Our ref: Shoalhaven Hospital Redevelopment (SSD-35999468)

1 November 2022

Subject: Response to Submissions

ATTACHMENT 1 – ADDITIONAL KEY ISSUES

SHOALHAVEN ST DROP-OFF OPTIONS

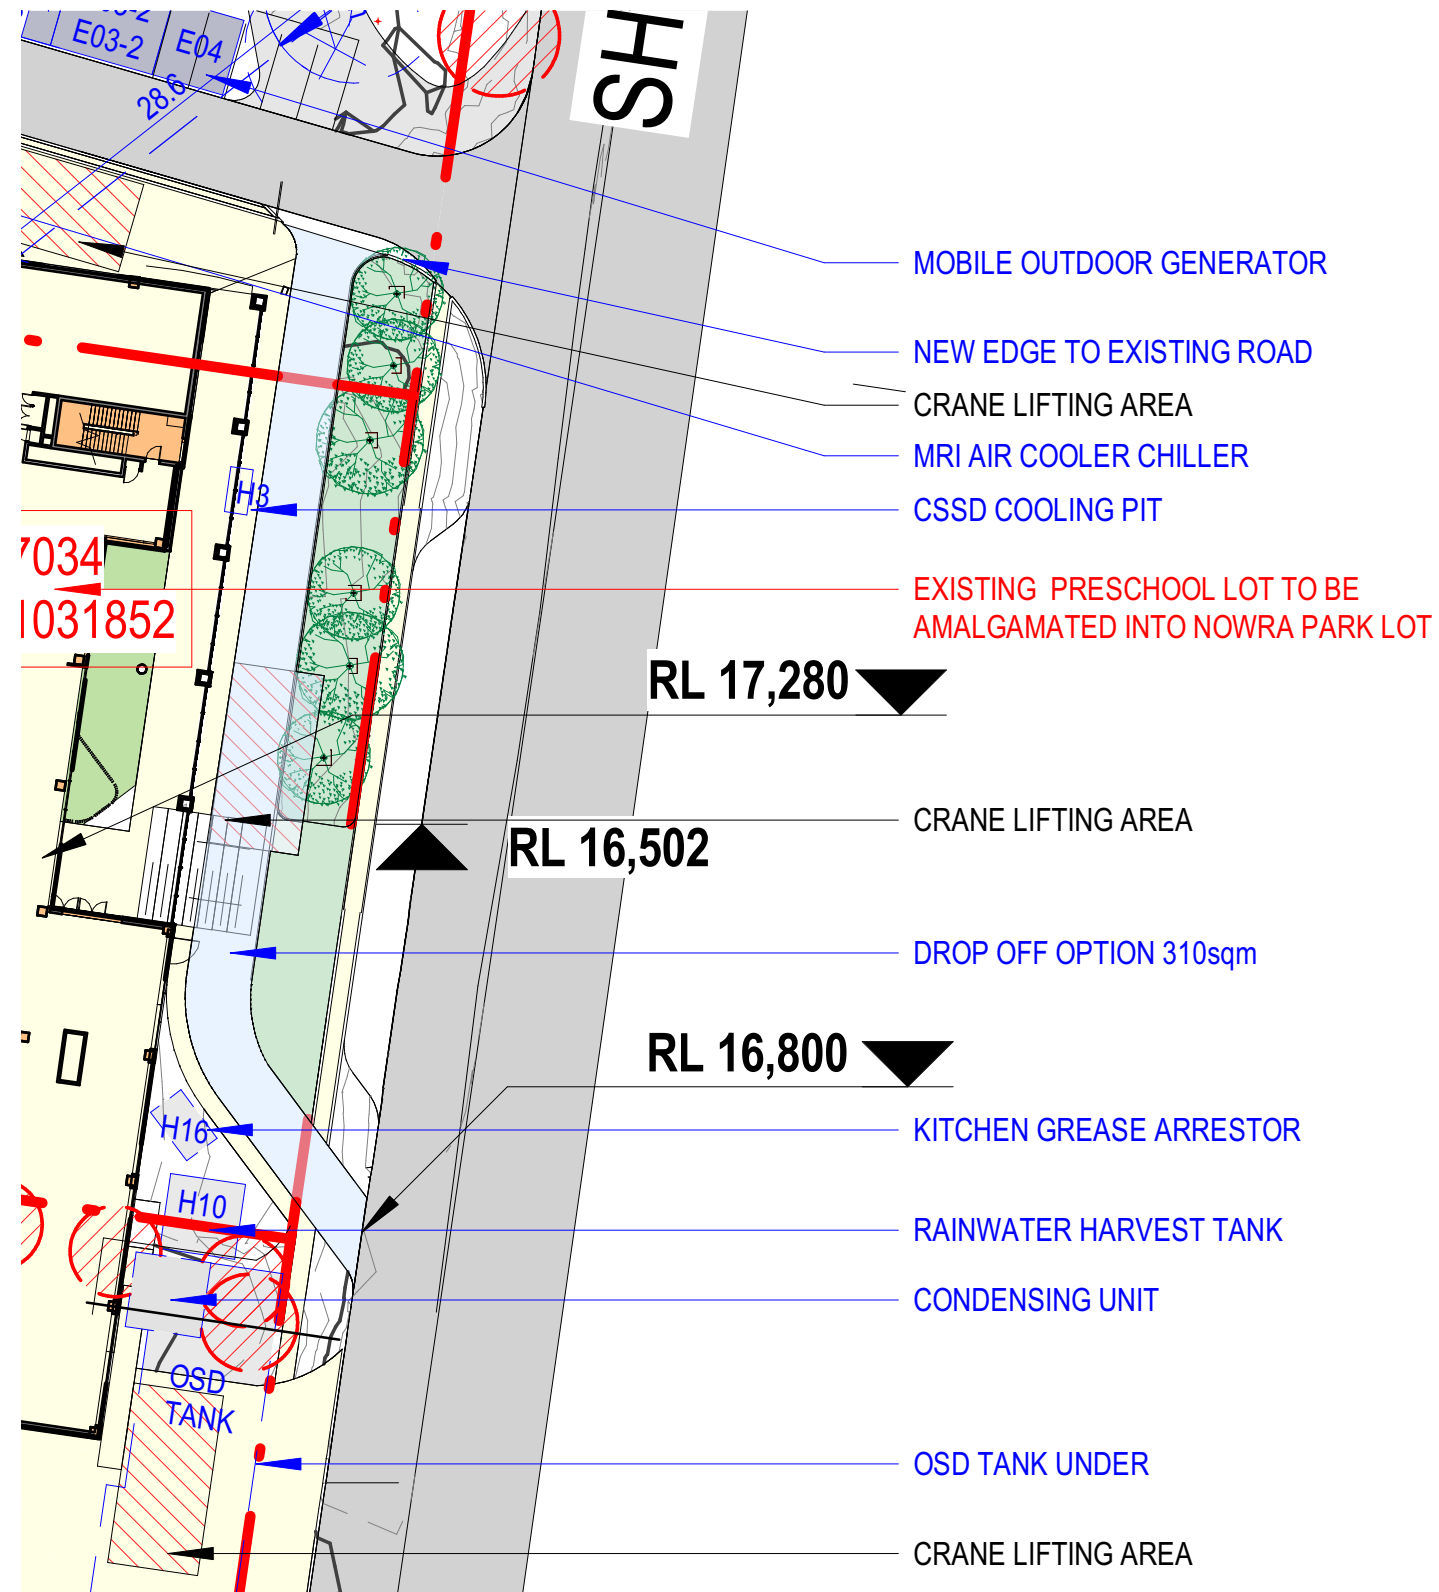
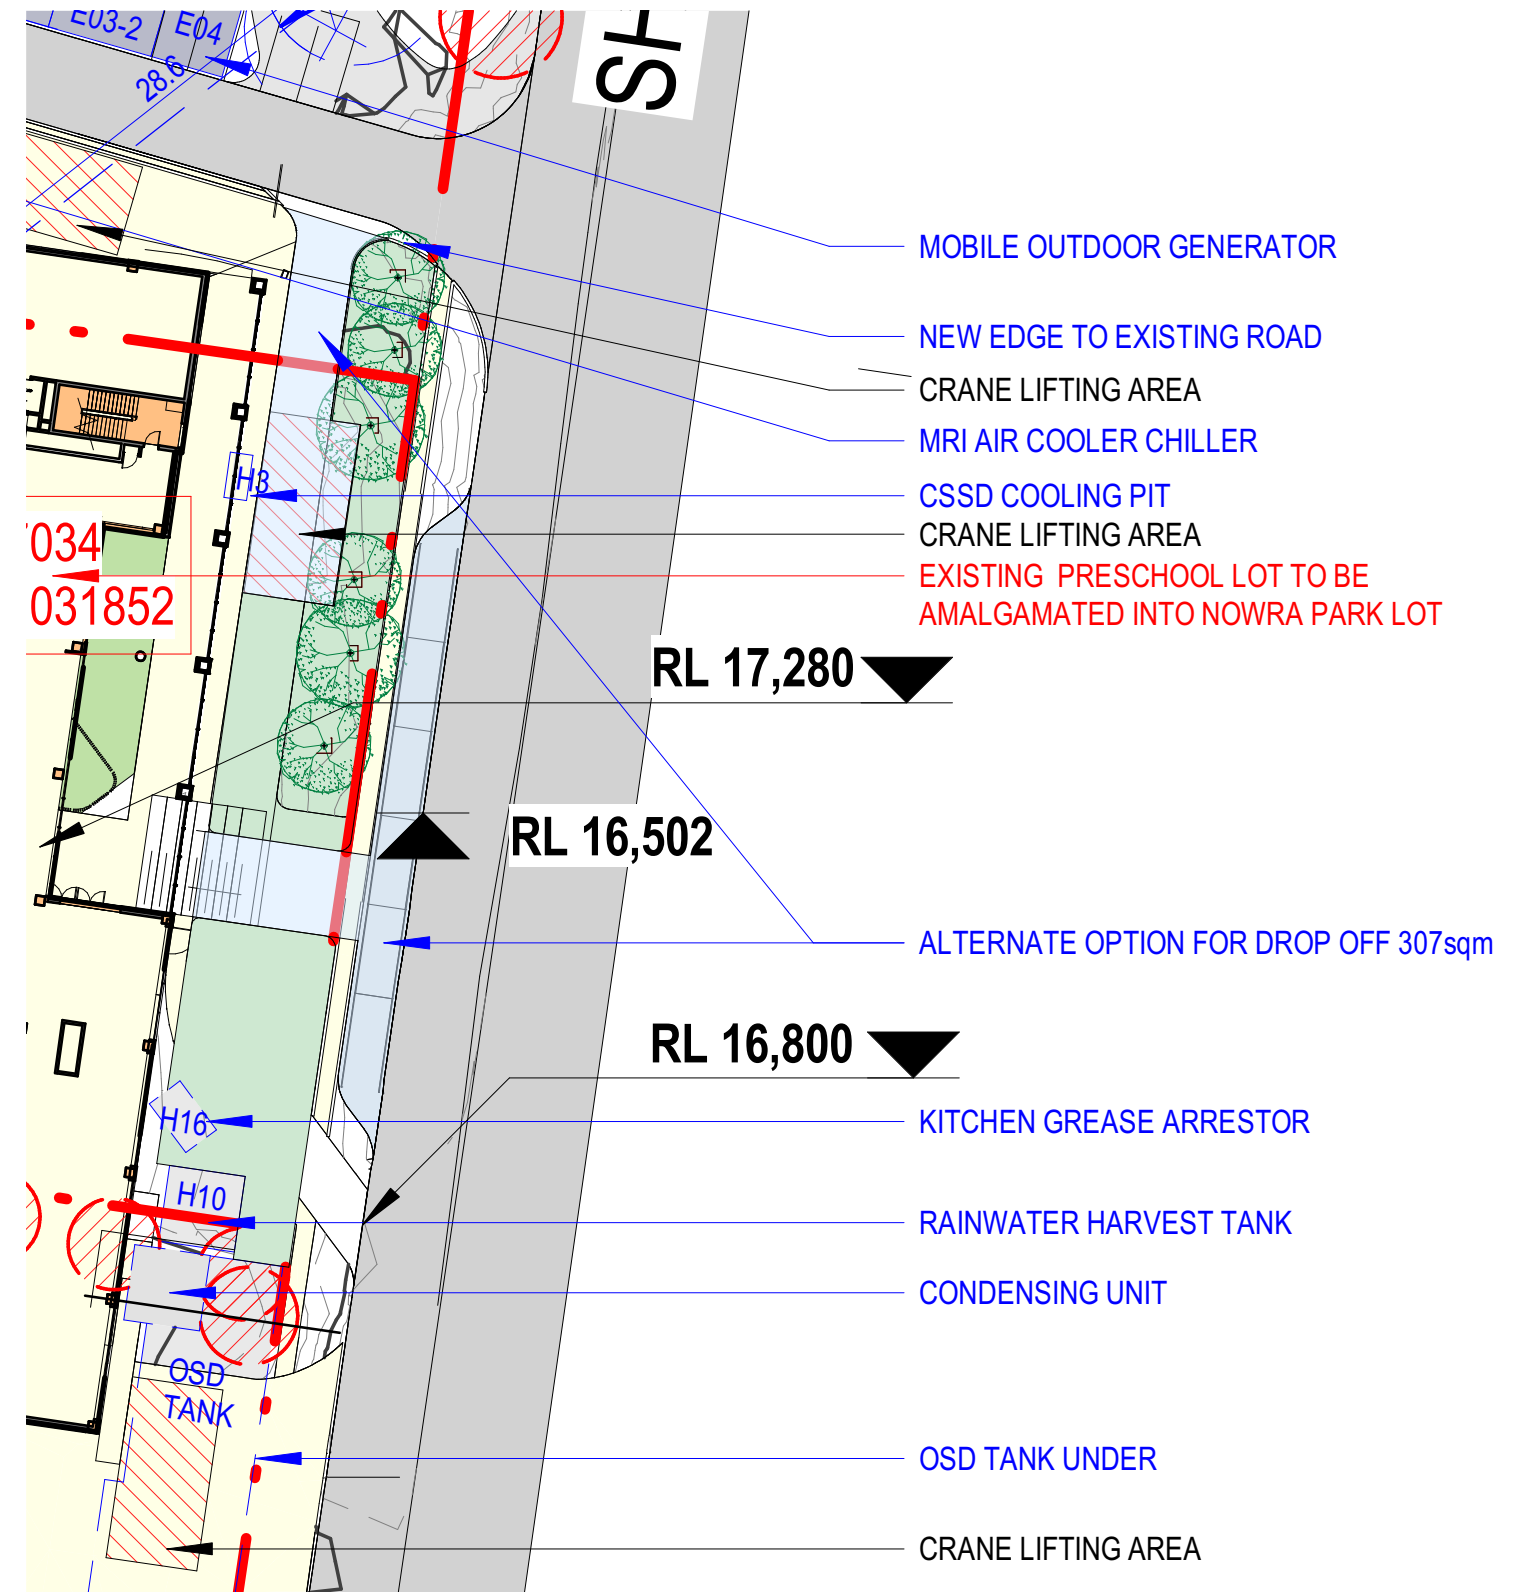
- Page 39 of the Architectural Design Report states that, in response to design issues raised by the SDRP, alternative options for the Shoalhaven Street drop-off are being explored to maximise landscaping to the streetscape. Provide details of the options explored in this respect.
